Application by Highways England**M25 Junction 10 / A3 Wisley Interchange Improvement project****The Examining Authority's second written questions and requests for information (ExQ2)****Issued on 18 February 2020**

Question to:		Question:	
3.	Air quality and human health		Surrey County Council response
2.3.6	Applicant and Local Authorities	<p>Have the air quality implications of the Proposed Development for Ripley been robustly assessed within the ES, having particular regard to the number and suitability of receptor properties that have been used [paragraphs 5.3 and 5.4 of REP1/041] and the extent to which the Applicant's modelling has been verified and modified against the monitoring data that is available for Ripley?</p> <p>With regard to the statement in REP2-022 that the largest change was assessed to occur at Receptor 6 but was classed as 'small', please explain the significance of this change in EIA terms and whether it affects the conclusions of the ES.</p>	This is not a matter on which SCC can comment. Air quality monitoring and management is a District and Borough responsibility and therefore GBC and EBC are the planning authorities with access to the relevant expertise

Rev: C01

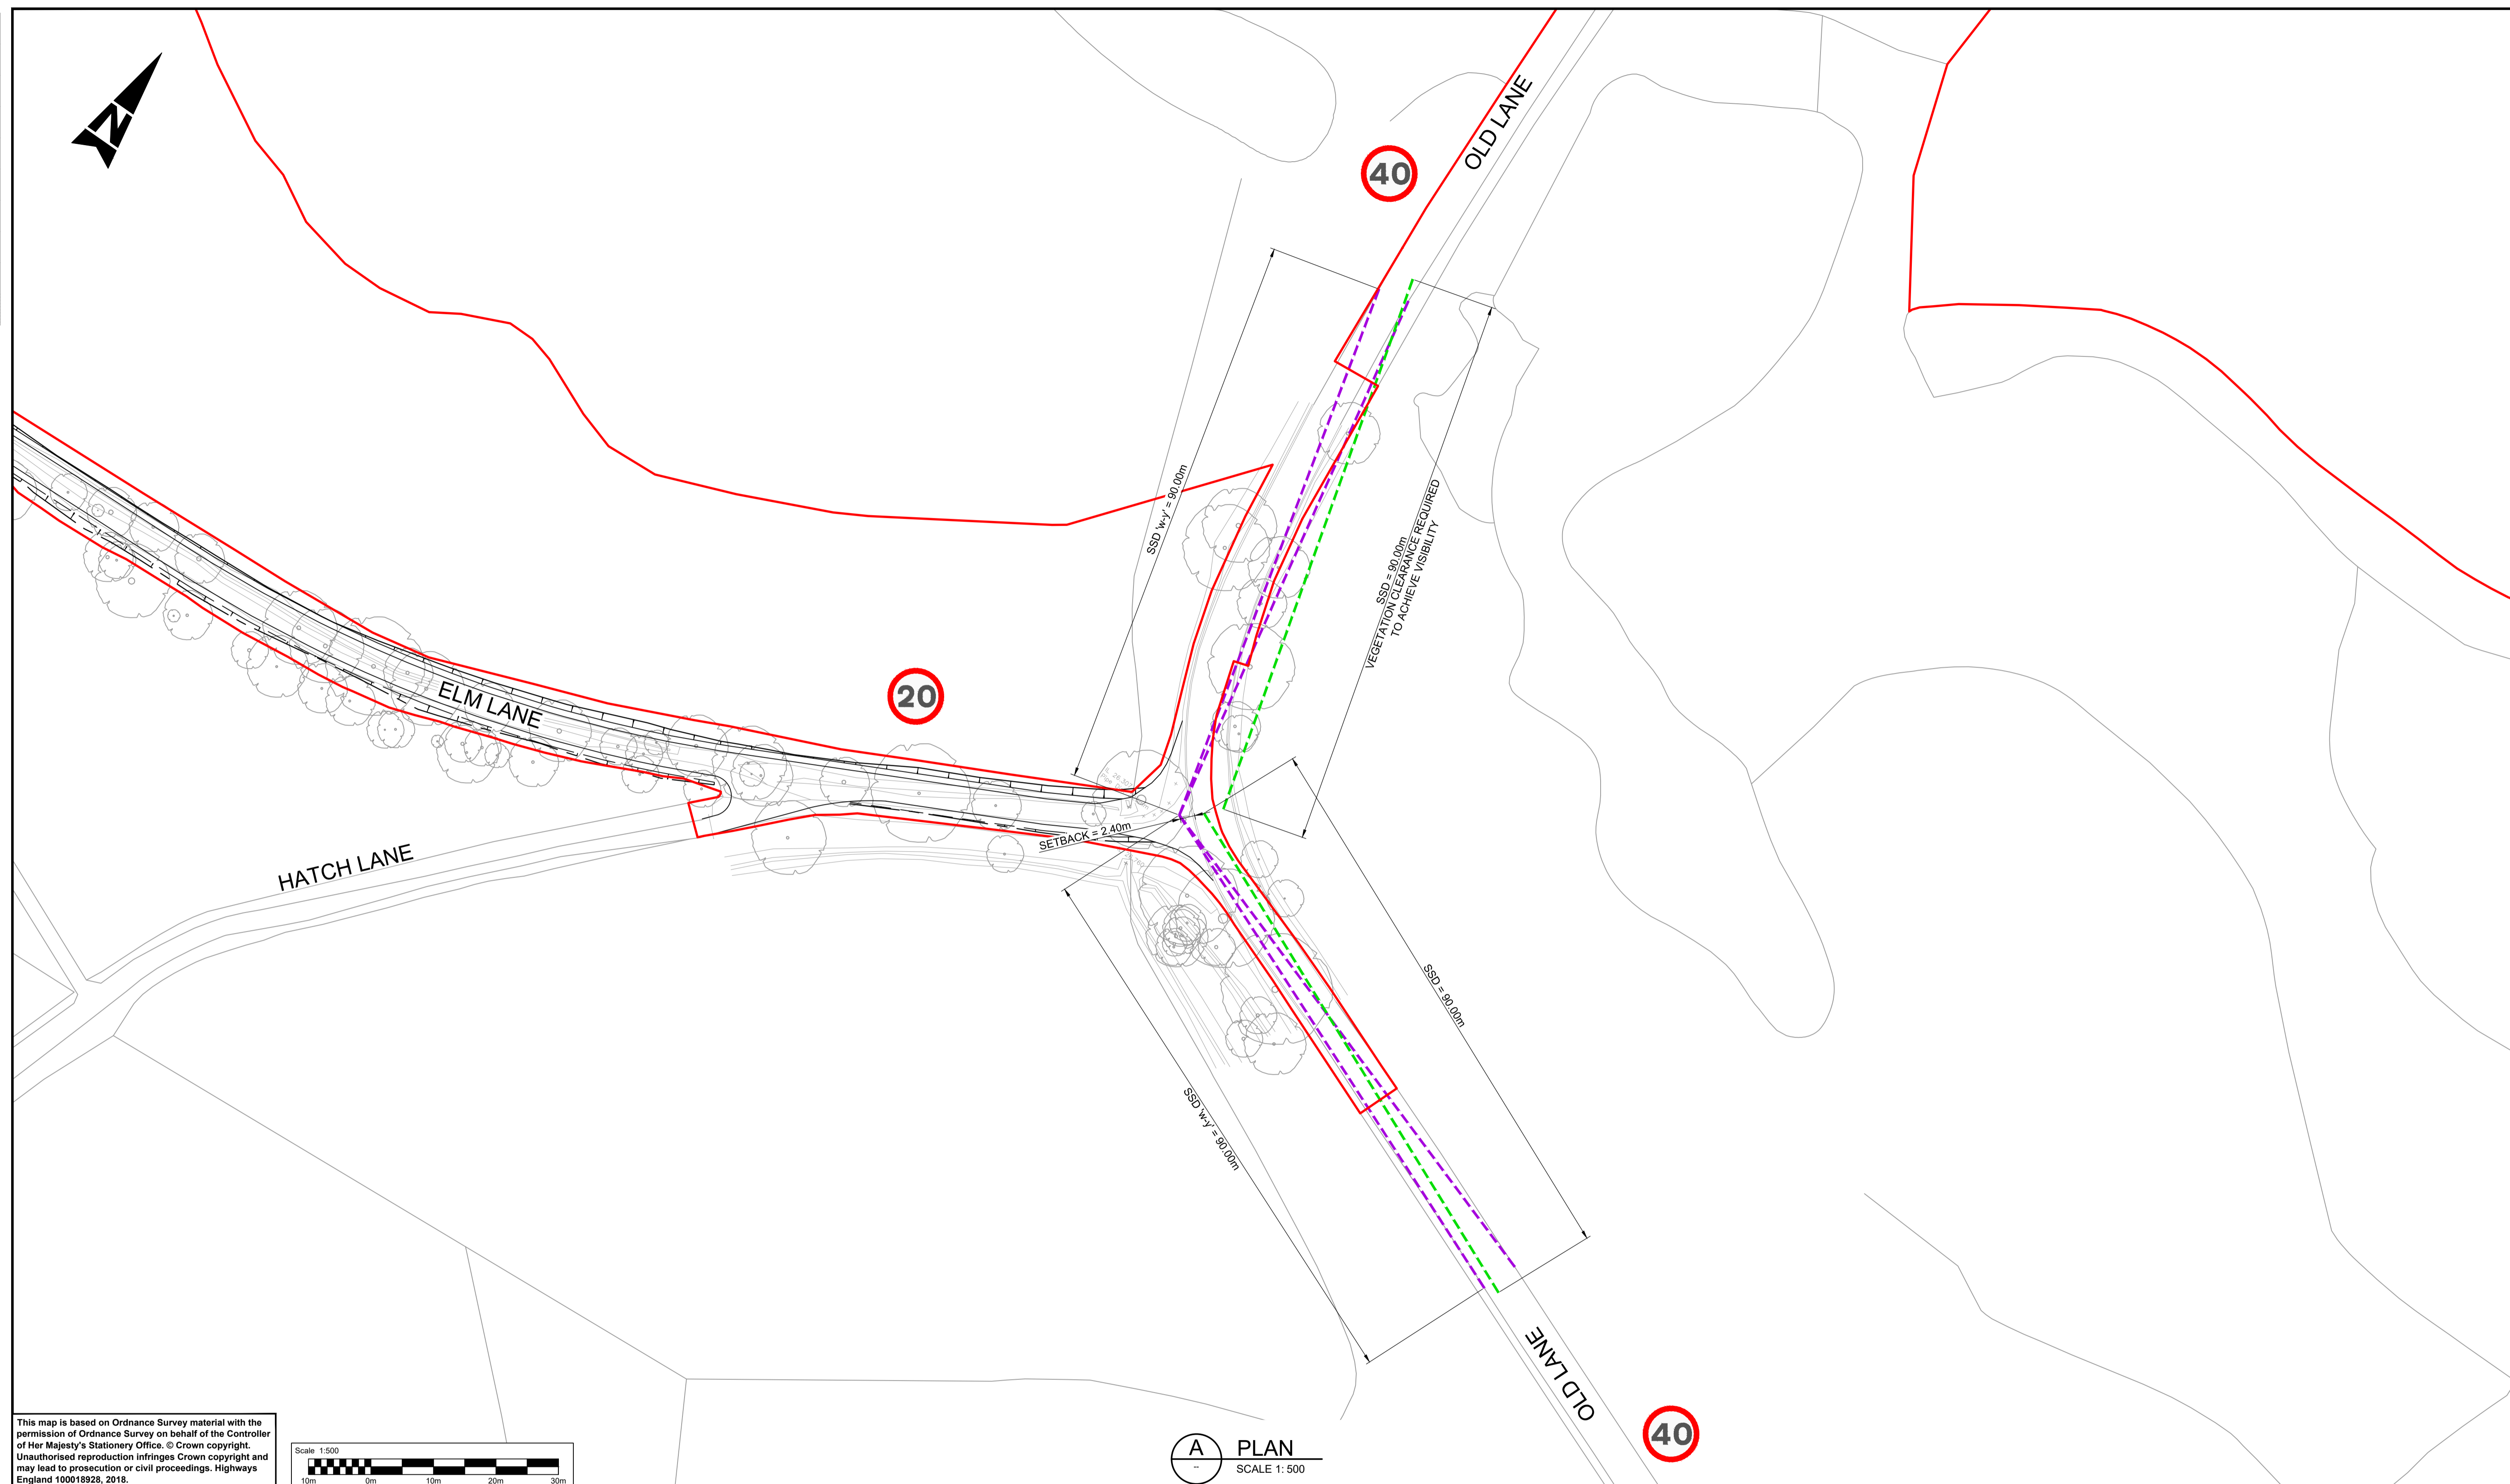
<p>b) The plots that SCC have seen do not meet the required standards, so SCC would like to see the mitigation measures that the applicant is proposing. Under Construction (Design and Management) regulations (CDM Regs), Highways England are the designer and measures are therefore to be determined by the proposer.</p> <p>SCC also consider that this is a consideration to measure on site for actual conditions, as the plans will not allow seasonal variations e.g. to vegetation.</p> <p>c). Vegetation clearance appears to be required beyond the red line. This raises a number of issues as the works are outside the DCO boundary. The proposed work to improve sight lines impact SCC land that is managed by Surrey Wildlife Trust on SCC's behalf. It is SSSI and SPA and the proposed works are not covered in the EIA or HRA. SCC assume these need to be assessed and included as an addendum to each document. SCC would also like to be assured that Natural England have no issues with these proposals as a local authority, we have a duty to engage with the Habitats Regulations.</p> <p>Regarding the works themselves, SCC assume these could take the form of tree and scrub removal across the inside of the bend. SCC acknowledge that this could improve light reaching the pond and reduce leaf fall into it, both being beneficial. There is a mix of pines and deciduous trees, the pines can be simply felled and they will not regrow. However, the</p>	Design speed kph	120	100	85	70	60	50	V2/R	Stopping sight distance (metres)								Desirable minimum	295	215	160	120	90	70	-	One step below desirable minimum	215	160	120	90	70	50	-
Design speed kph	120	100	85	70	60	50	V2/R																												
Stopping sight distance (metres)																																			
Desirable minimum	295	215	160	120	90	70	-																												
One step below desirable minimum	215	160	120	90	70	50	-

Question to:		Question:
		<p>splays could be provided on either side of Elm Lane's junction with Old Lane?</p> <p>c) Drawing HE551522-ATK-HGN-XX-SK-CH-000036 within Appendix A of REP4-006 shows visibility splays drawn to accord with DMRB CD109 and CD123 standards inclusive of some vegetation clearance. To achieve the DMRB standards would the required vegetation clearance shown on drawing HE551522-ATK-HGN-XX-SK-CH-000036 be within or extend beyond the red line areas for land plots 24/4 and 24/4a shown on sheet 24 of AS-002?</p> <p>d) If visibility splays of the relevant standard would be unachievable within the extent of land</p>
		<p>deciduous trees will coppice and form dense regrowth very quickly after cutting unless the stumps can be removed or treated. They will be difficult to treat due to the proximity to water and this may not be possible. This dense regrowth will effect visibility and will require more regular maintenance. These are maintenance responsibilities that will fall to SCC and so SCC would require suitable maintenance monies to be provided to cover this ongoing maintenance.</p> <p>d) .SCC consider that the main issue is right turning traffic entering Elm Lane not being seen by following southbound traffic (i.e. drivers of following vehicles with restricted sightlines will not be able to view a stationary vehicle waiting to turn right).</p> <p>Before any meaningful measures can be suggested, the available stopping sight distance/visibility envelope should be measured to confirm what can be achieved. If the stopping sight distance is one, or even two or more steps, below desirable minimum then it is a creating a known concern / setting a precedent. Typical remedial measures that SCC's Safety Engineering team could employ in such situations on an existing highway concern would be high friction surfacing, appropriate junction warning signing with distance plates, slow road markings.</p> <p>In addition, an issue which has not been raised is the concern for two-way traffic in Elm Lane. If a vehicle attempts to enter Elm Lane at the same time a vehicle wishes to exit, there does not appear to be with width in the side road to accommodate two lanes of traffic. This could result in stationary traffic waiting to turn right, waiting in Old Lane (potentially for prolonged periods if several vehicles exit Elm Lane at once). Also it could result in vehicles reversing back from Elm Lane onto Old Lane. SCC query whether the bellmouth needs to be widened to allow two-way traffic as well as passing places in Elm Lane.</p> <p>SCC also has concerns regarding the achievable forward sight stopping distance/visibility envelope at the A3 northbound off slip to A245 Byfleet Road within the red line boundary due to the change from a signal controlled arrangement to a free flow jet lane. This concern is also stated in our covering letter.</p>
